Application for a Non-Material Amendment Following a Grant of Planning Permission

Demolition of the existing single storey rear and construction of a single storey rear and side infill extension at 142 Wood Vale, SE23, together with installation of a new window to the top floor at the side elevation and rooflights to the sloped roof of the rear outrigger.

1. Upgrade rear extension roof covering material from fibre-cement 'slate', to natural slate.
2. Upgrade part area of fibre-cement wall cladding panels in garden elevation to continuation of sliding door system, partly from obscured glass to mask kitchen storage behind.

3. Sketch Proposals
SE Elevation
rev.A

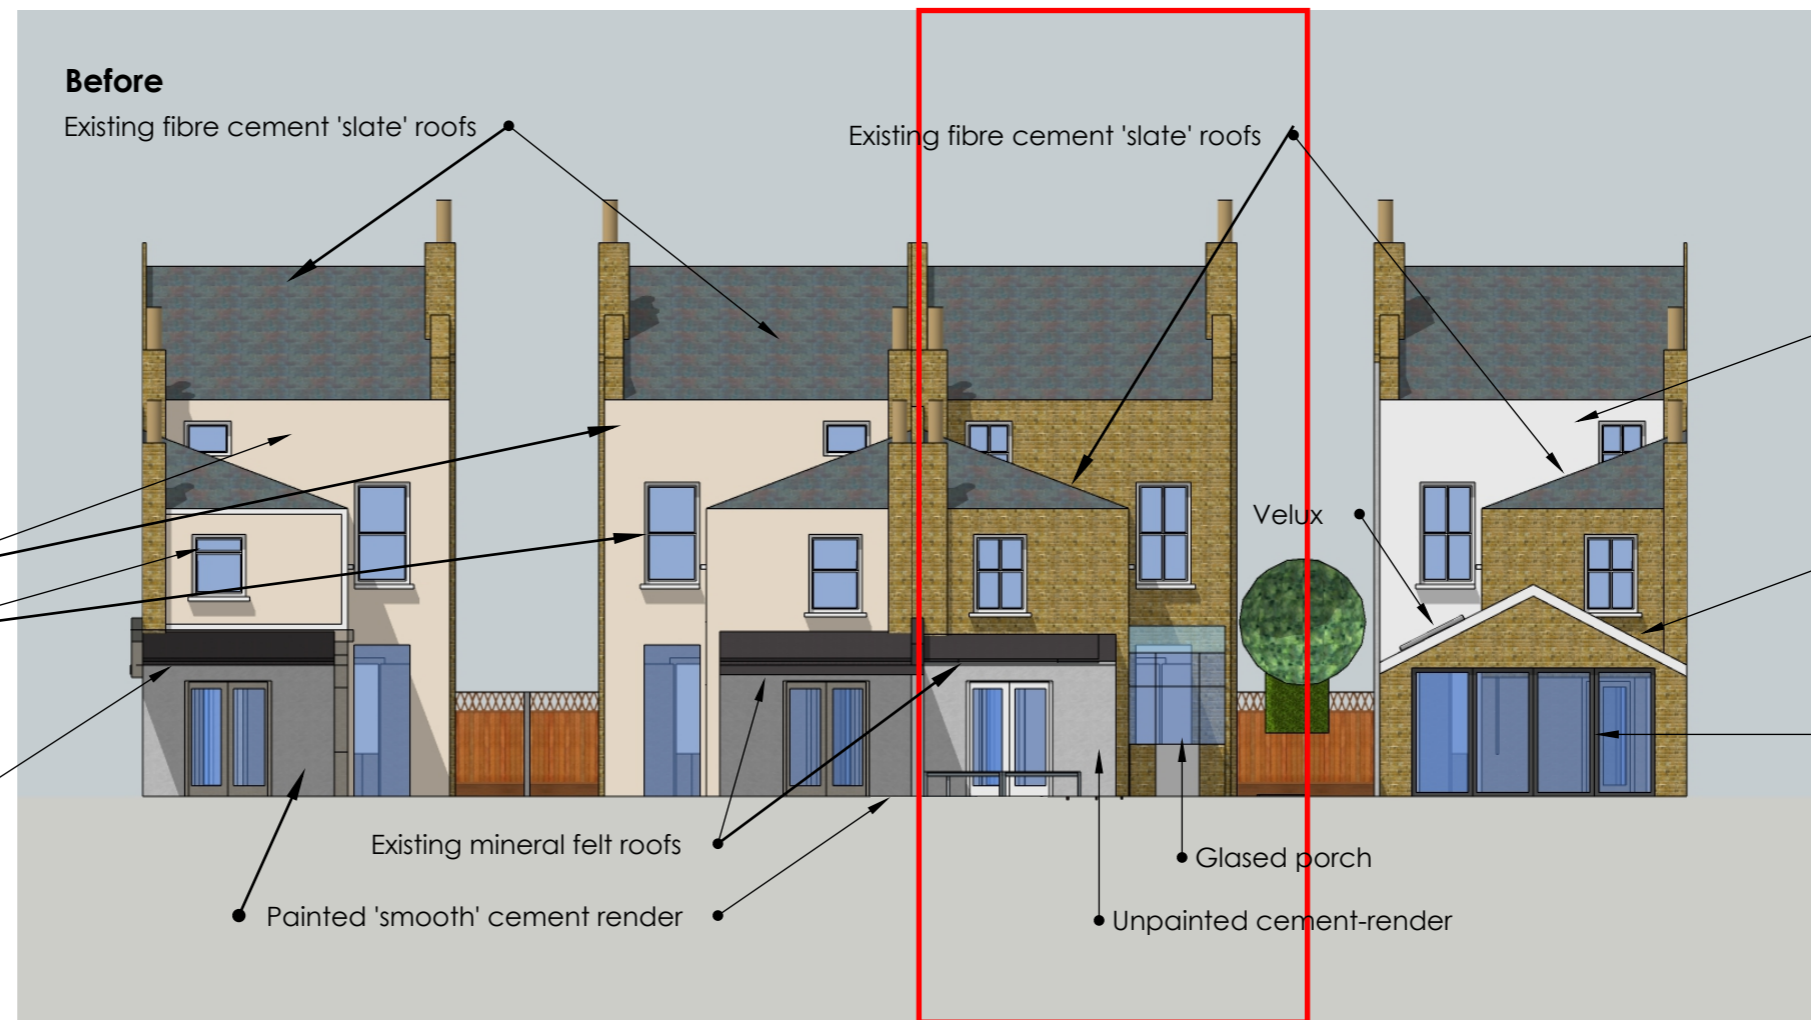
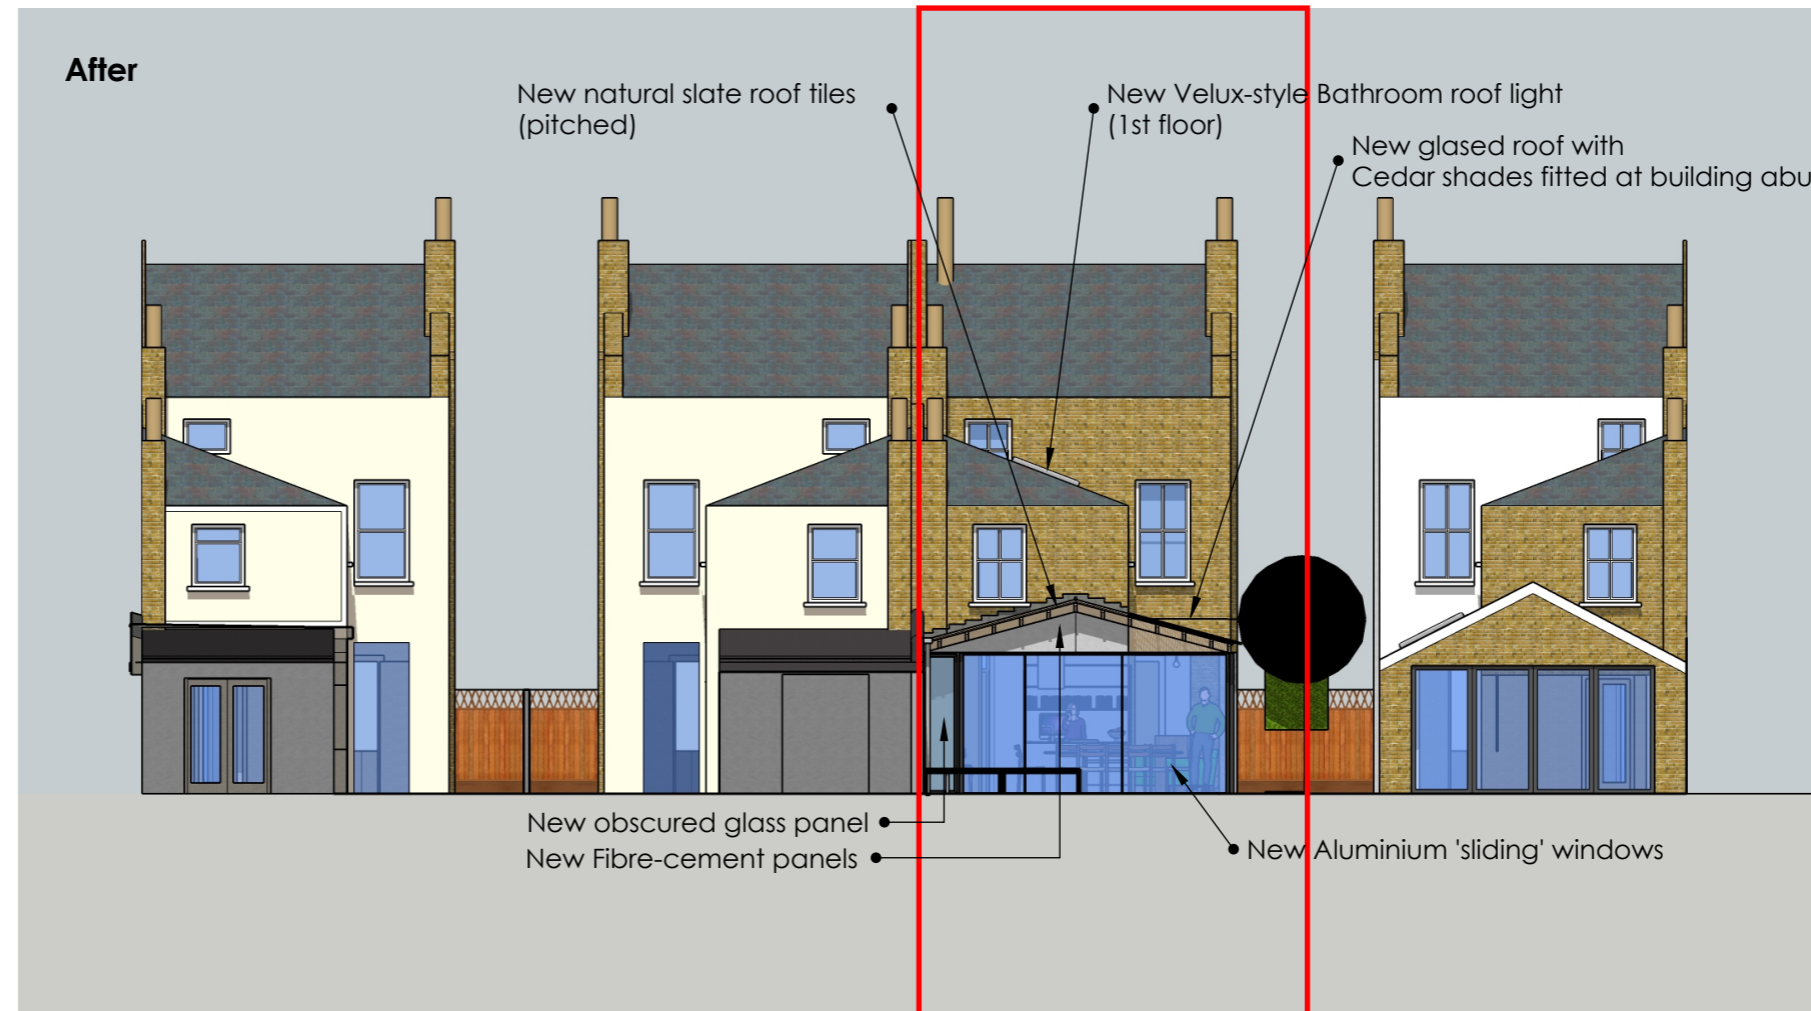
1. Increase quality of roof covering material from fibre-cement to natural slate.
 2. Simplify design, also simplify construction detailing to create a higher performance, unbroken, thermal envelope that minimises 'cold bridging'.
- Please note Josh Knowles supported 'the choice to use glass in the rear elevation of this extension' in his original pre-app report, and also that this amended design now matches the neighbour at 144. Mr Knowles also cited "the extension is unlikely to present unreasonable harm to neighbouring property". The amendment is in an elevation NOT facing a neighbour and NOT visible from the public realm. It does NOT increase overlooking (it is not overlooked) and does NOT result in greater visual intrusion to neighbours. Building Regs approval is granted based on the amended proposals.

3. Sketch Proposals - SE Elevation rev.A
